RE: LAND SOUTH OF SOUTH SIDE, STEEPLE ASTON.

Further to the grant of planning permission (Ref: P19/02948/F) at the above site, please find enclosed an application made by Rectory Homes seeking a minor-material amendment to the approved plans for the site. The application has been submitted via the Planning Portal (ref: PP-09988277).

Rectory Homes are seeking approval of a minor-material amendment application to make a number of design changes to plots 1, 2, 3, 4, 5, 6, 7 and 10. These changes are listed below:

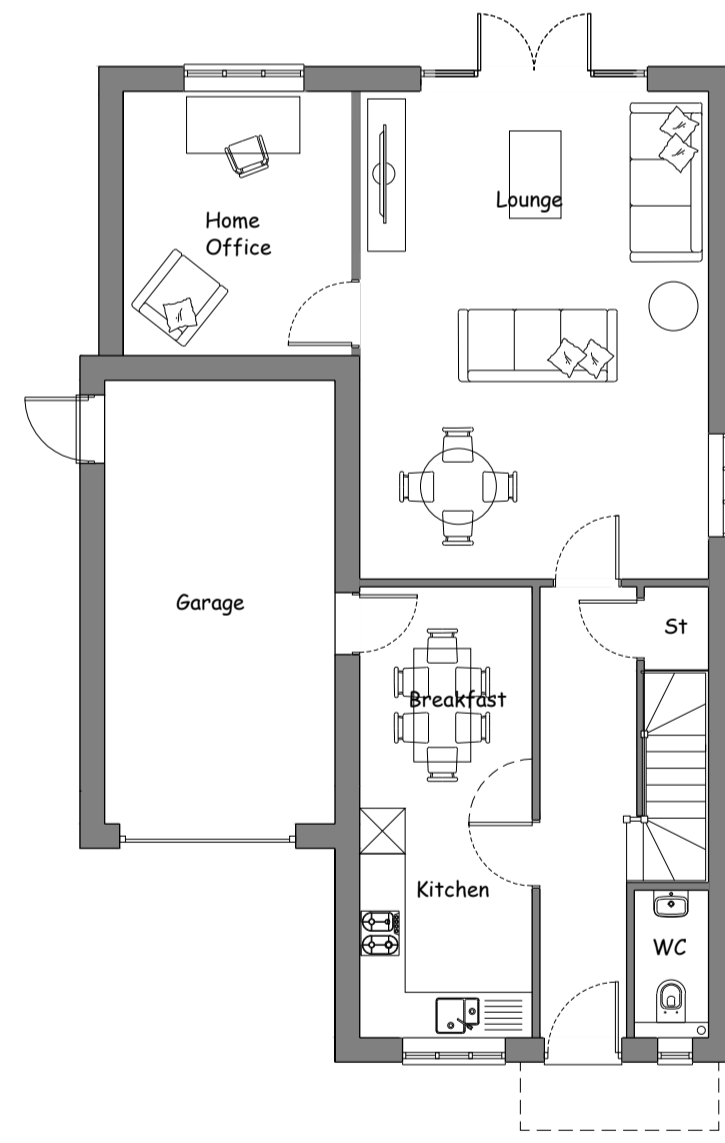
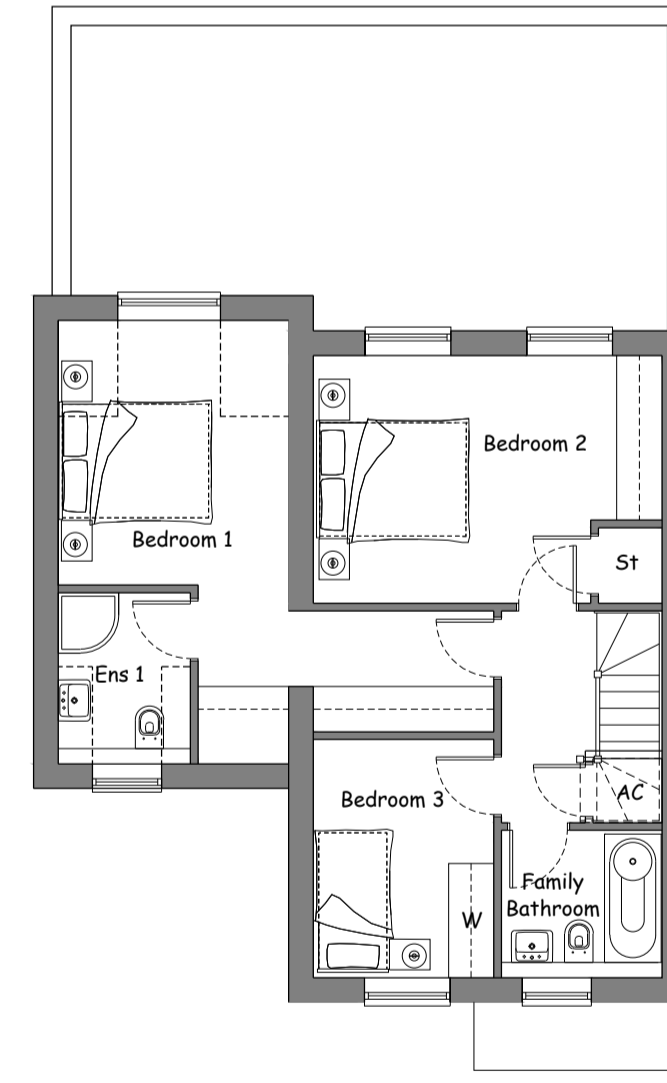
- **Plot 10:** Single storey extension to facilitate home office and extended kitchen / dining area.

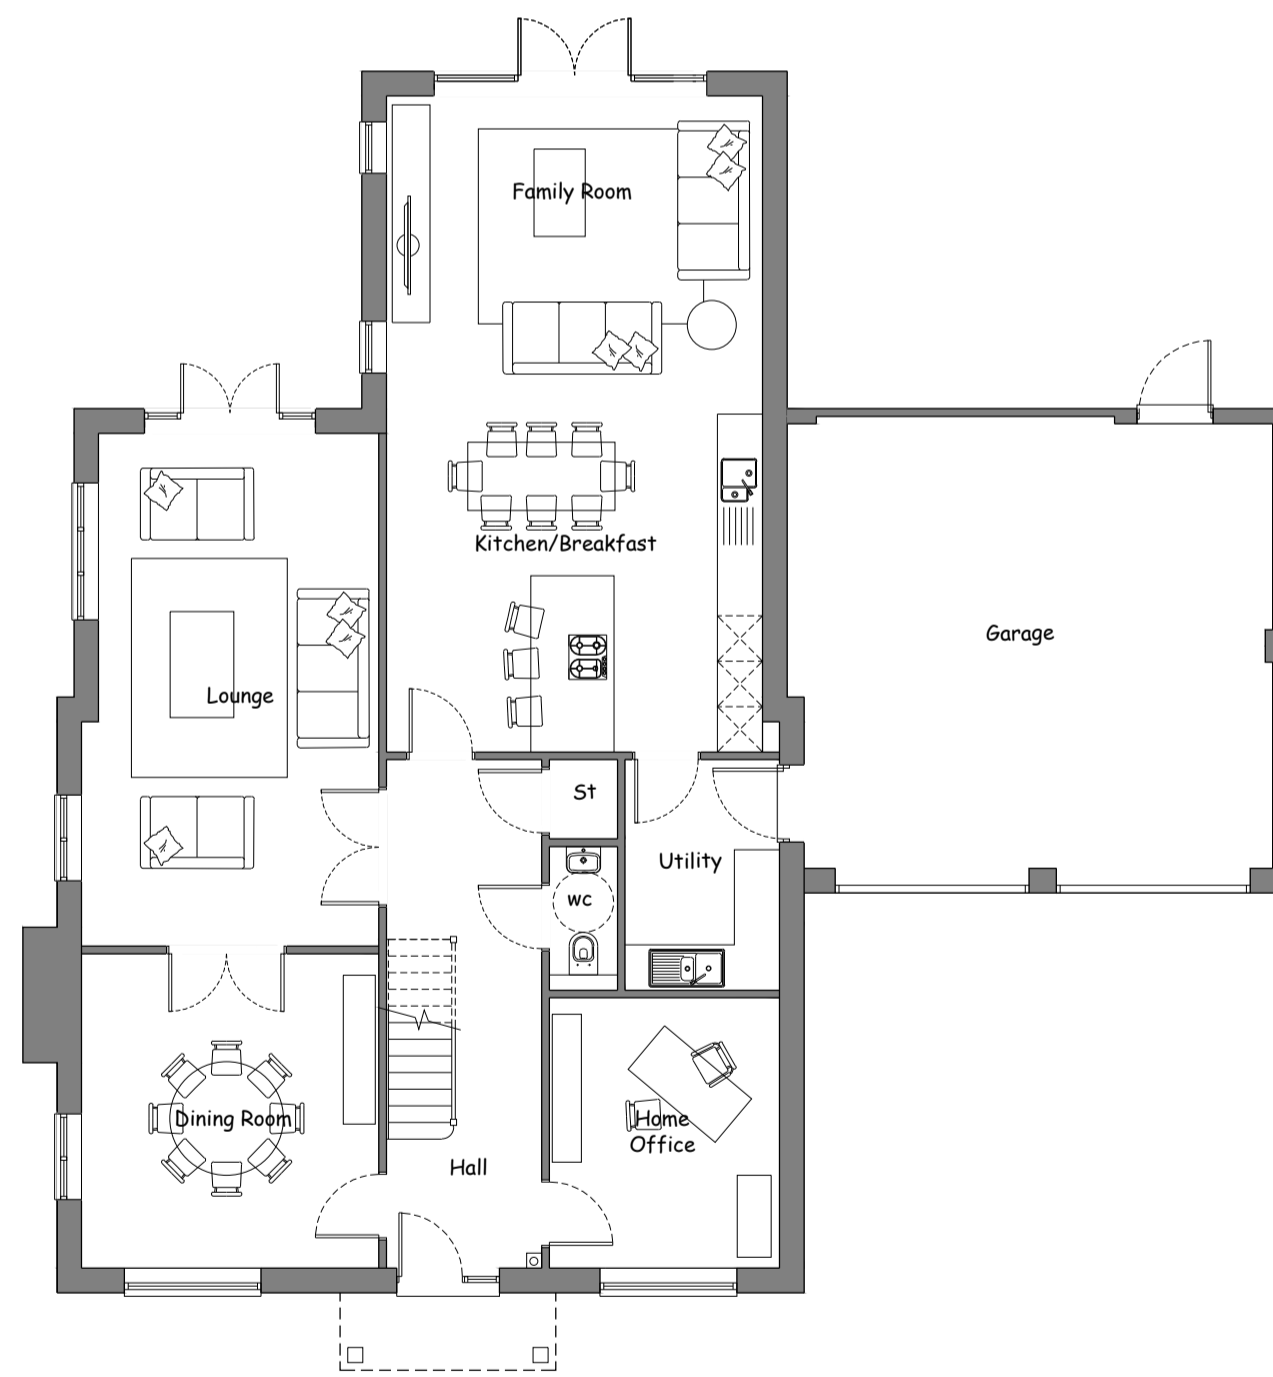
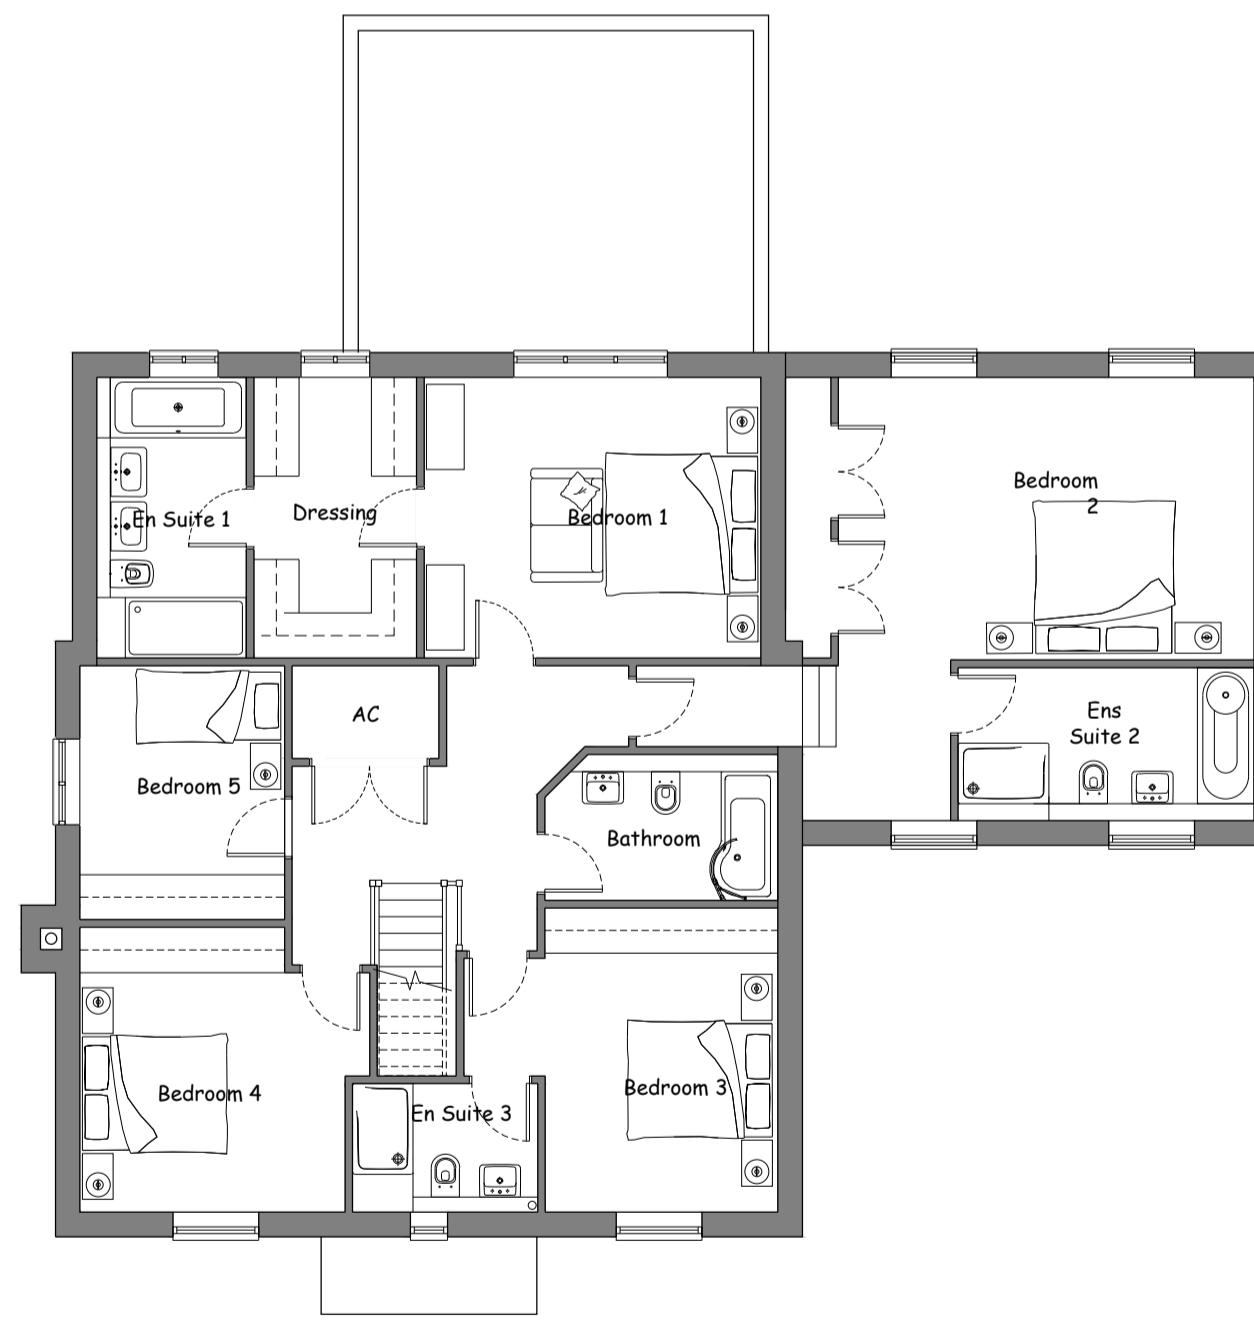
- **Plots 1 & 3:** Single storey rear extension and re-configuration of internal layout to include home office and extended kitchen / family room on the ground floor. Second storey rear extension to facilitate a dress room to the master bedroom;

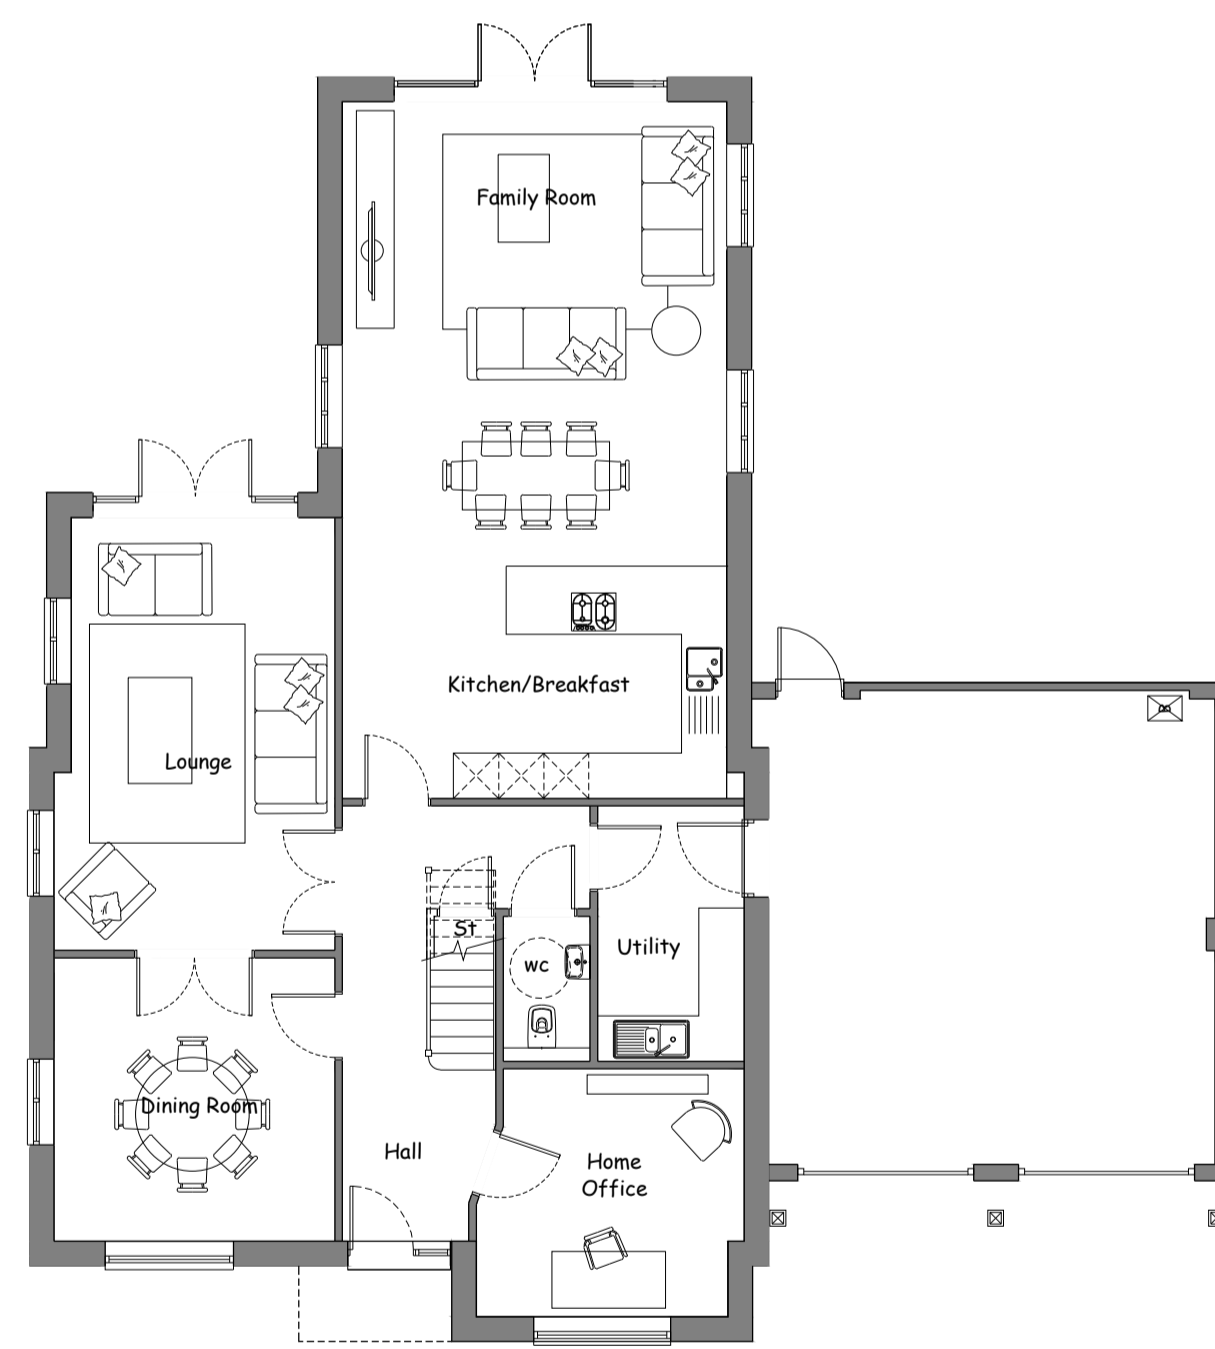
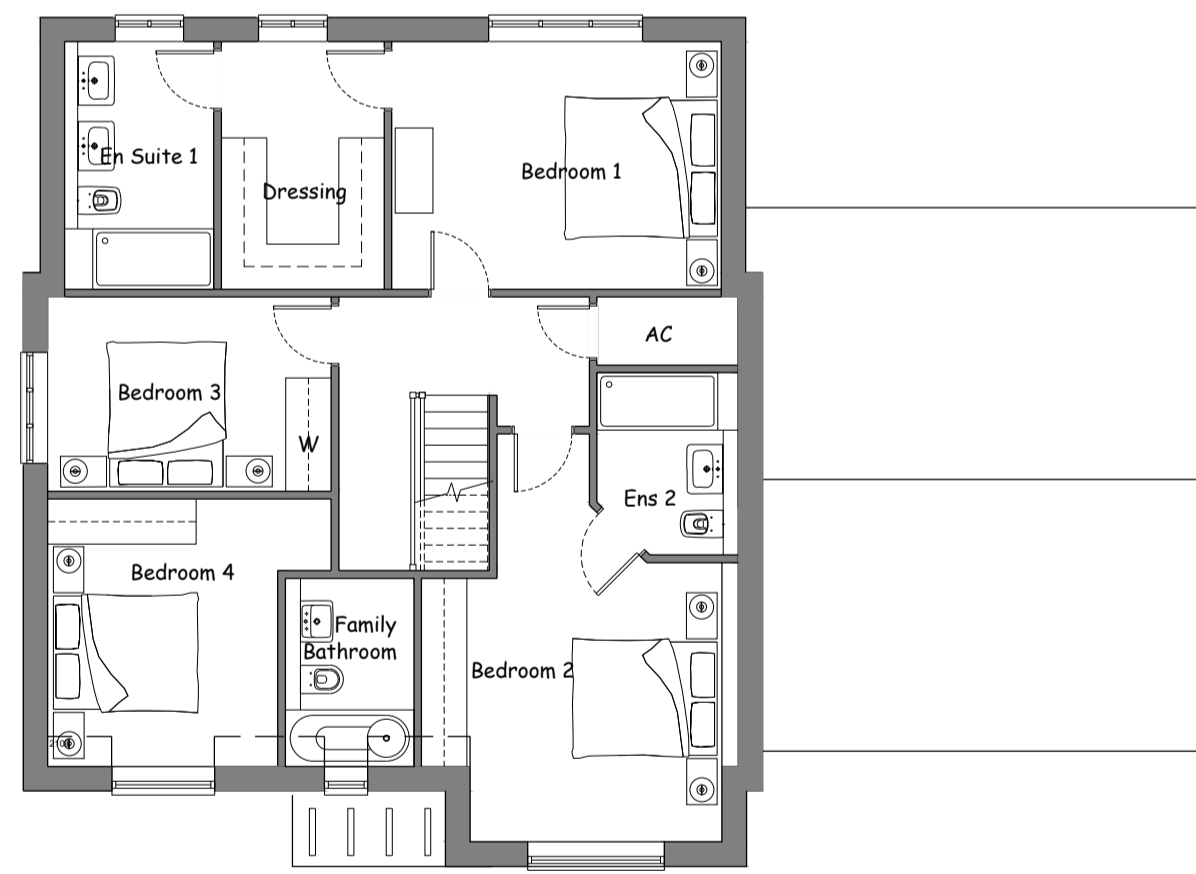
- **Plot 2:** Single storey rear extension and re-configuration of internal layout to include home office and extended kitchen / family room. Second storey rear extension to facilitate a dressing room to the master bedroom;

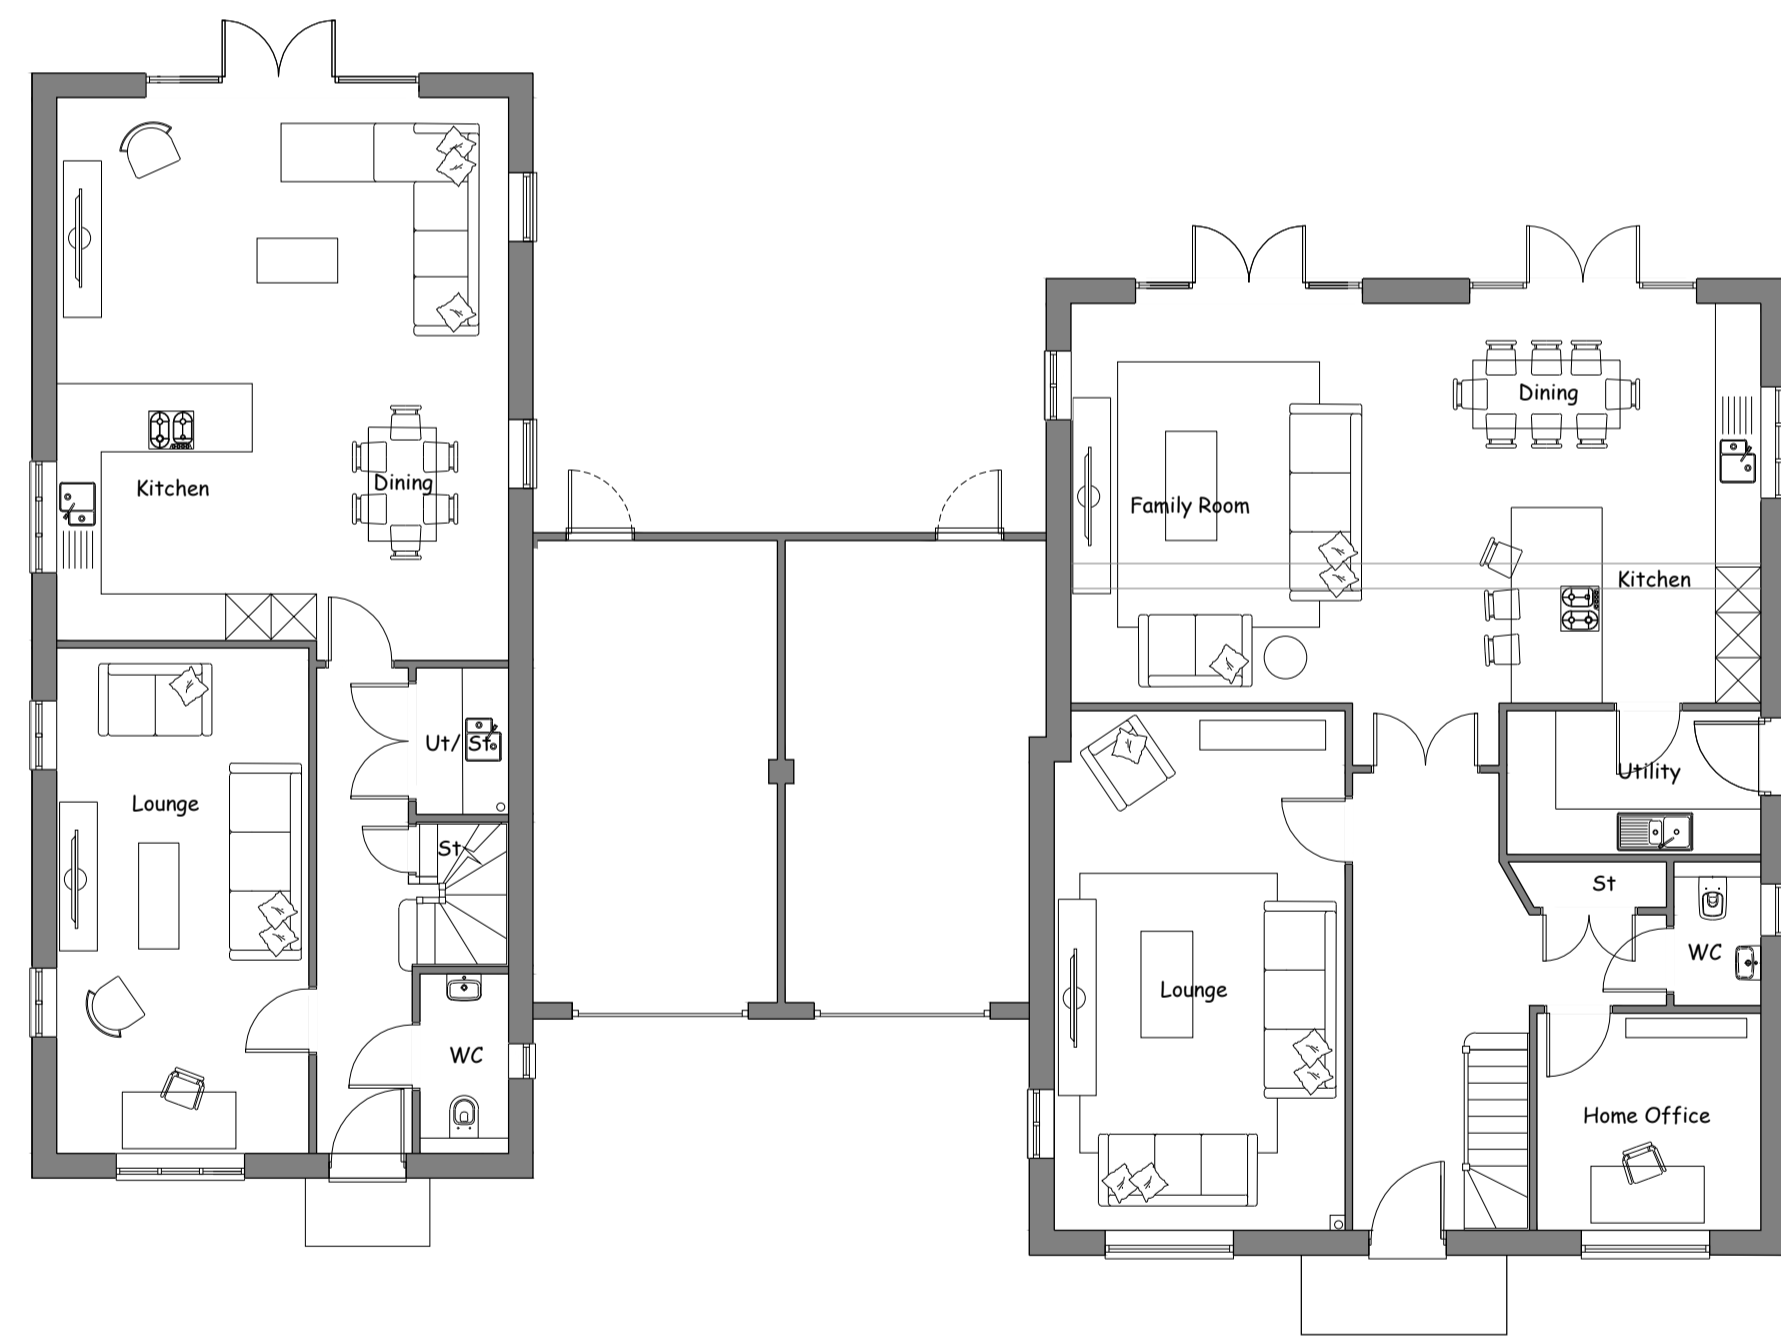
- **Plots 4 & 5:** Single storey rear extensions. Extended kitchen / family room / dining area to plot 4. New home office and extended kitchen / family room / dining area to plot 5;
